Minor Amendments to SSD-67895459-MOD-4
106 & 120-122 Smith St And 3a Charlotte St, Wollongong
Shop Top Housing with In-fill Affordable Housing

This letter has been prepared by Colliers Urban Planning on behalf of The Smith Street Development Partnership (the Applicant) for SSD-67895459-MOD-4 located at 106 & 120-122 Smith St And 3a Charlotte St, Wollongong (the site) to outline proposed minor revisions to the modification application.

2.0 Description of Proposed Revisions

Drawing #:	Rev:
DA-8303	1

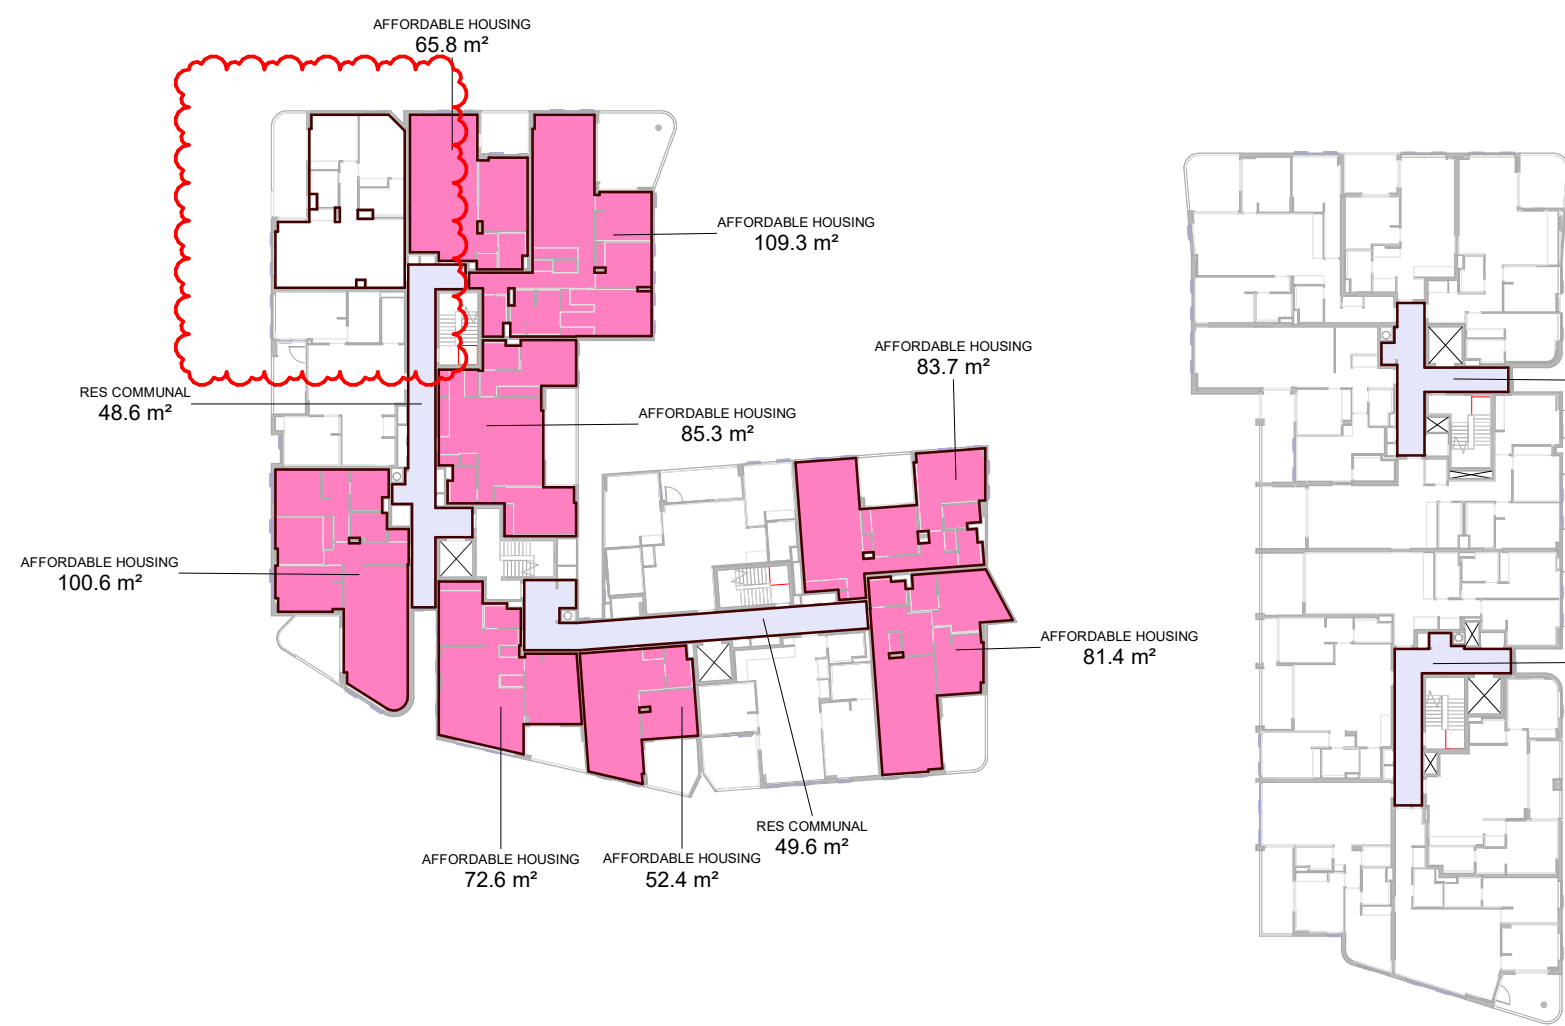
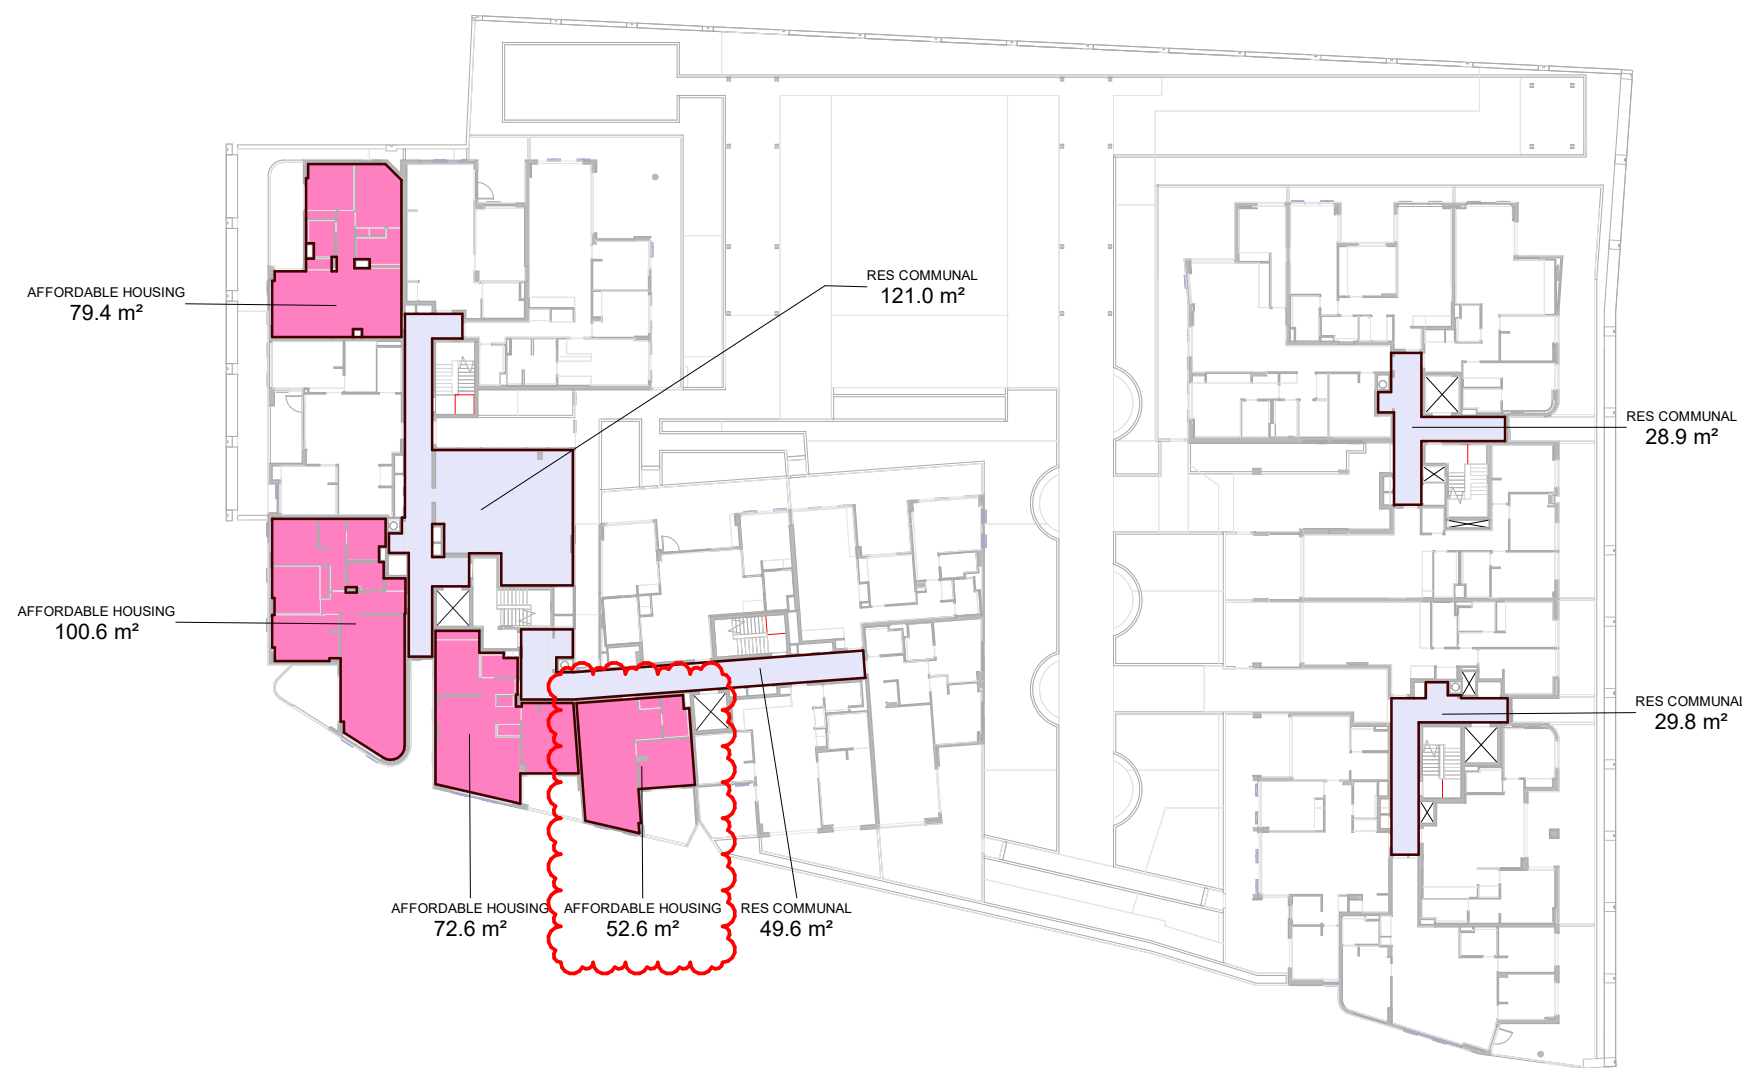
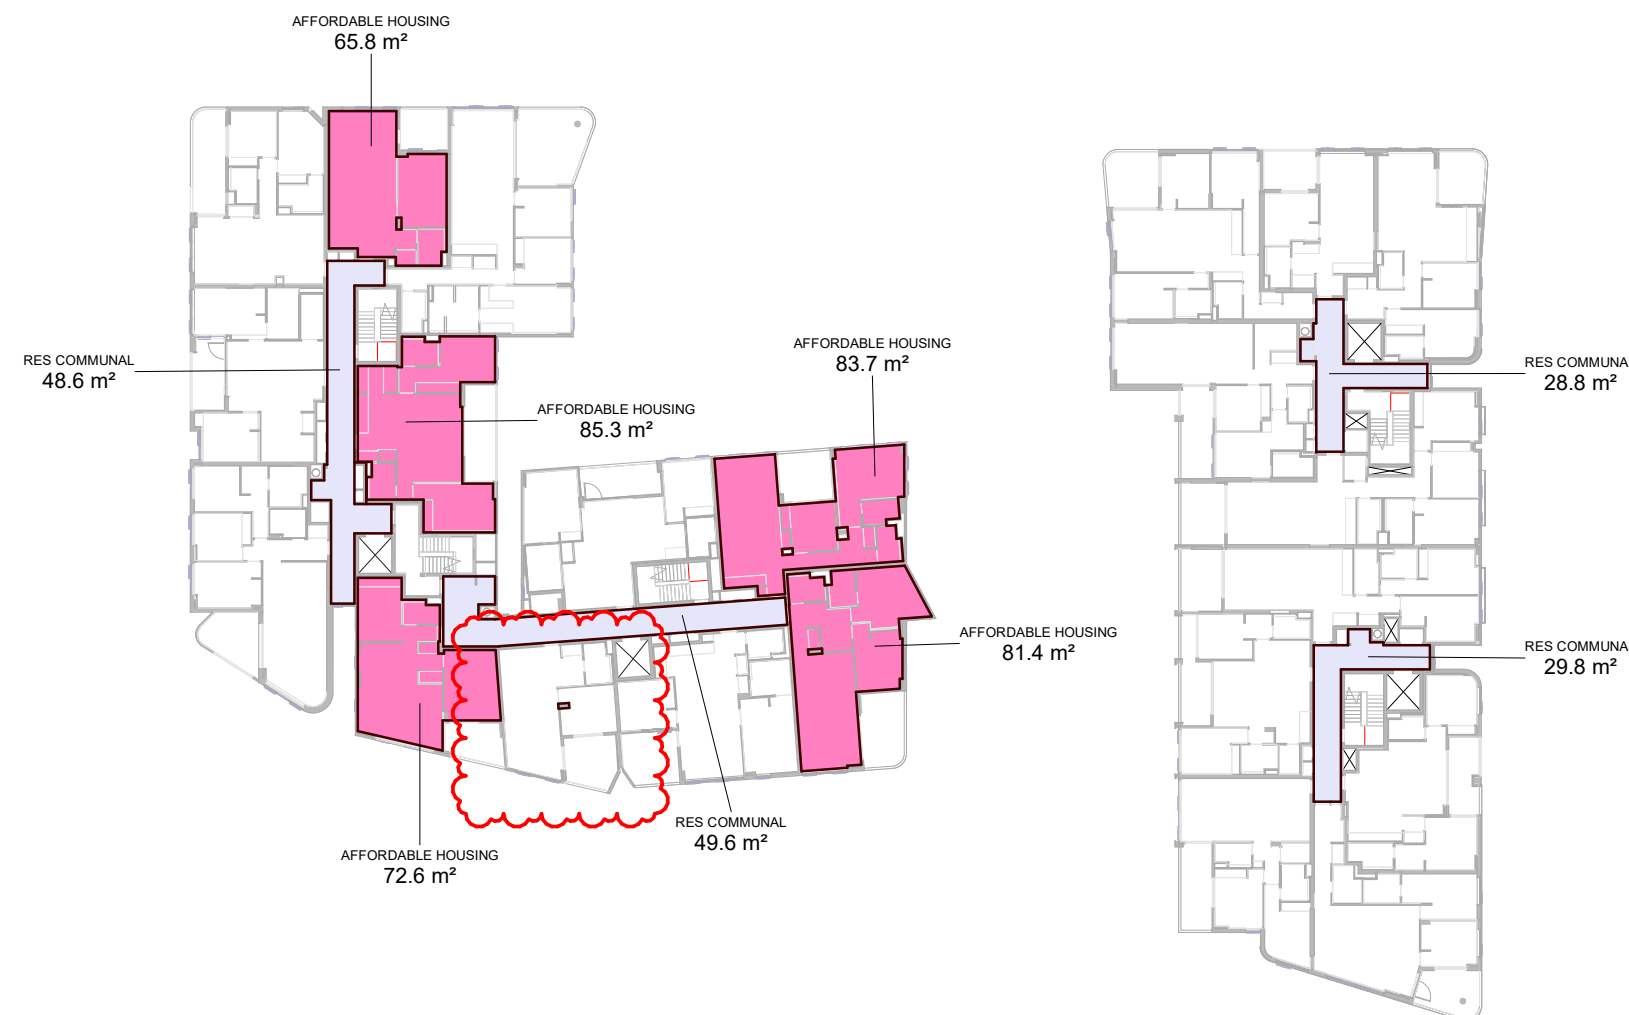
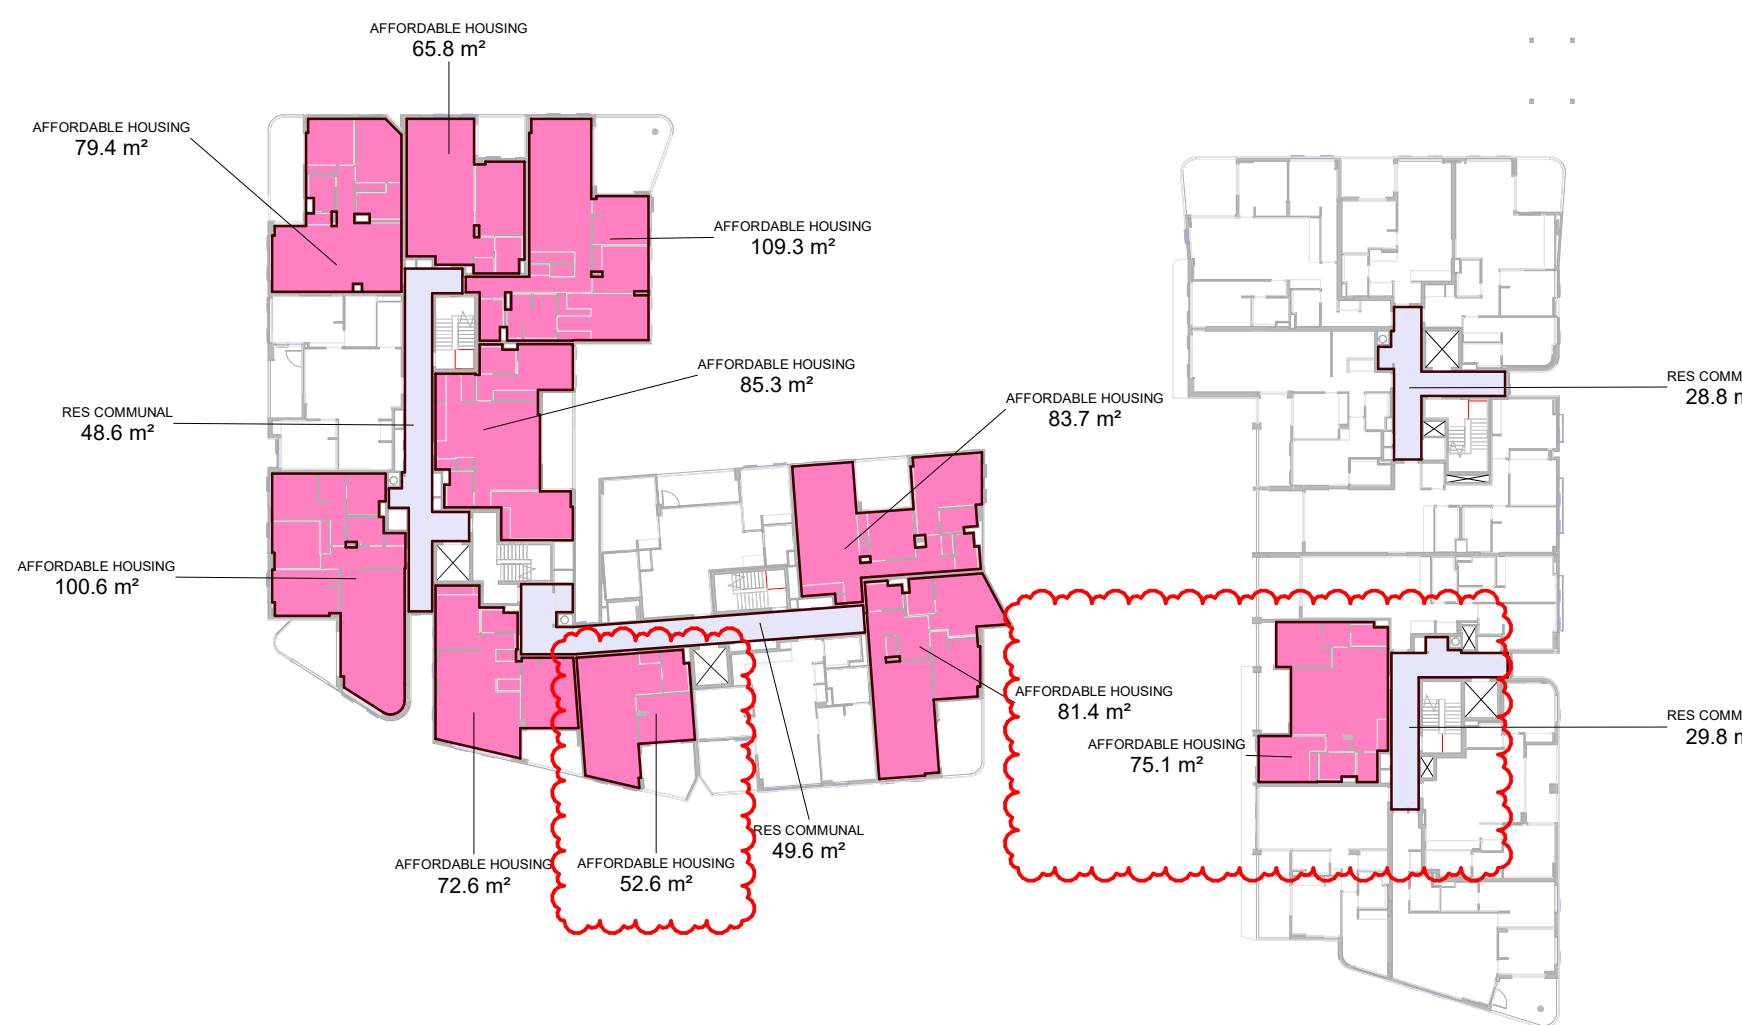
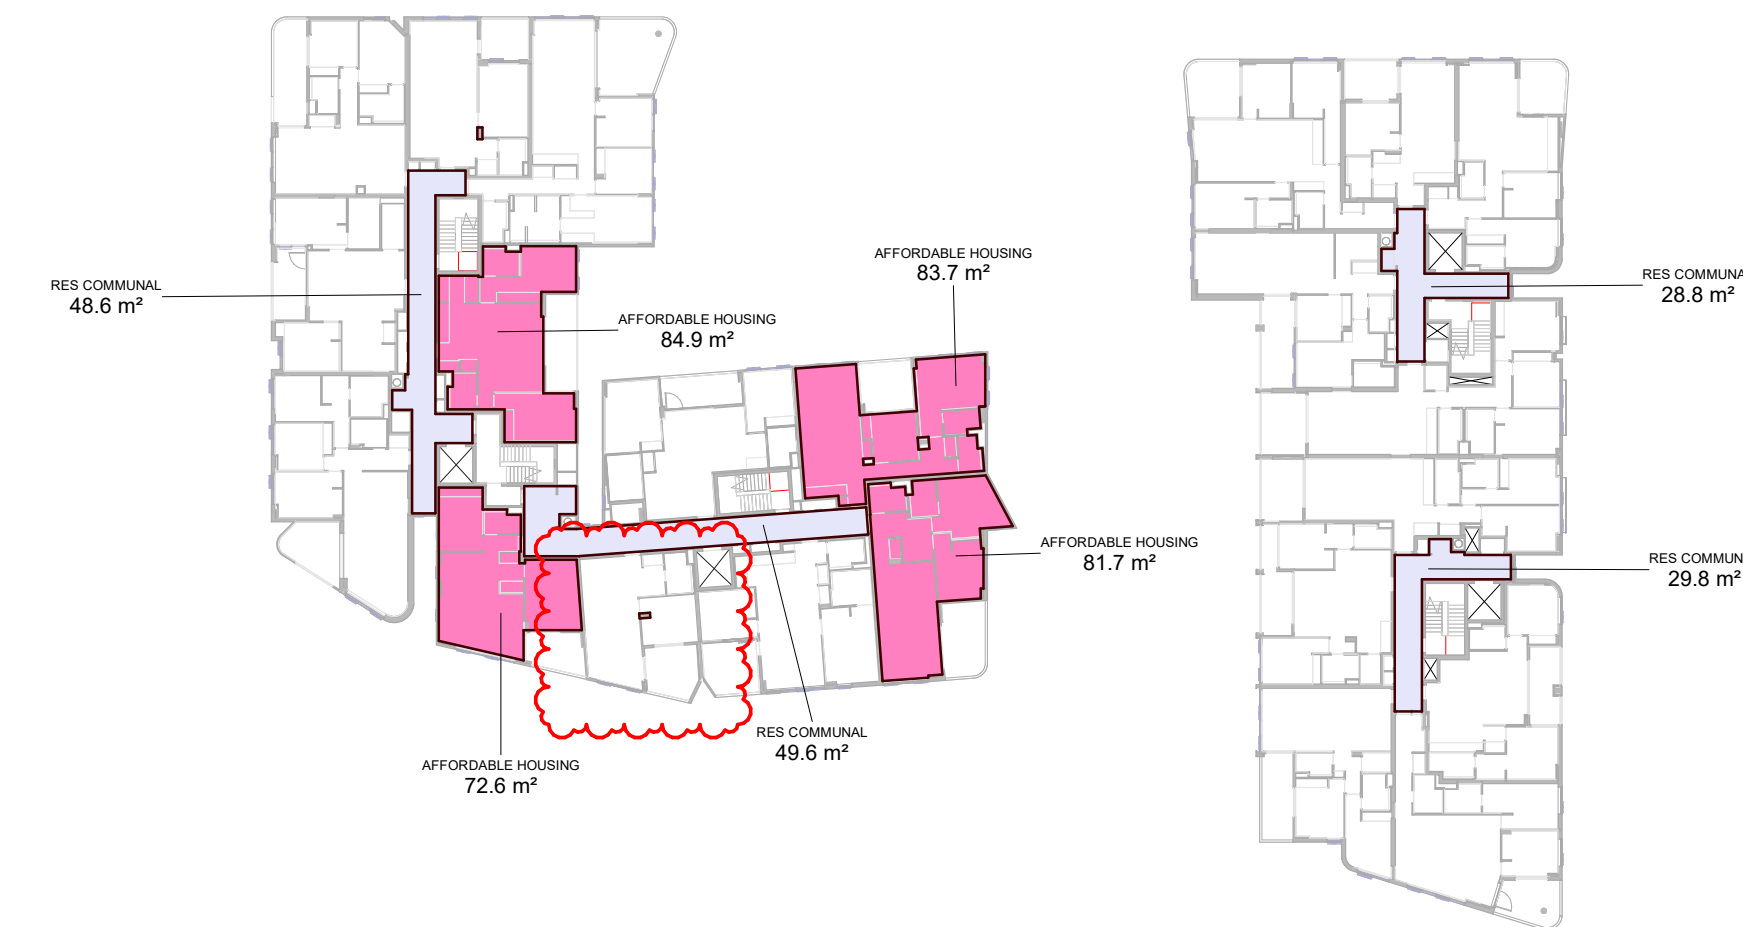
The proposed revisions seek a substitution of the location of the 3 x proposed affordable housing units, as set out in **Table 1**.

Direction	Building	Lvl	Apt No.	Beds	Area (m ²)	Notes
Remove	A3	5	5.05	1	52.4	1BR type swapped for a like unit
Remove	A3	6	6.05	1	52.4	1BR type swapped for a like unit
Remove	A4	4	4.03	2	79.4	To be replaced with A2-2.04 2BR unit
Add	A2	3	3.04	2	75.0	replaces the A4-4.03 2BR
Add	A3	2	2.05	1	52.4	replaces an A3 1BR
Add	A3	3	3.05	1	52.4	replaces an A3 1BR

The amendment involves the replacement of nominated affordable housing units with alternative apartments of the same typology and consistent floor area within the development. The substitution maintains the approved affordable housing quantum, with the provision continuing to comprise 15% of the development's gross floor area. Importantly, the approved unit mix of affordable housing remains unchanged, comprising 11 one-bedroom, 15 two-bedroom and 5 three-bedroom affordable housing apartments.

The minor revision improves the distribution of affordable housing across the development. Whilst affordable housing is currently concentrated within Buildings A3 and A4, the proposed substitution introduces an affordable housing apartment into Building A2, resulting in a more integrated and dispersed distribution of affordable housing dwellings across the site.
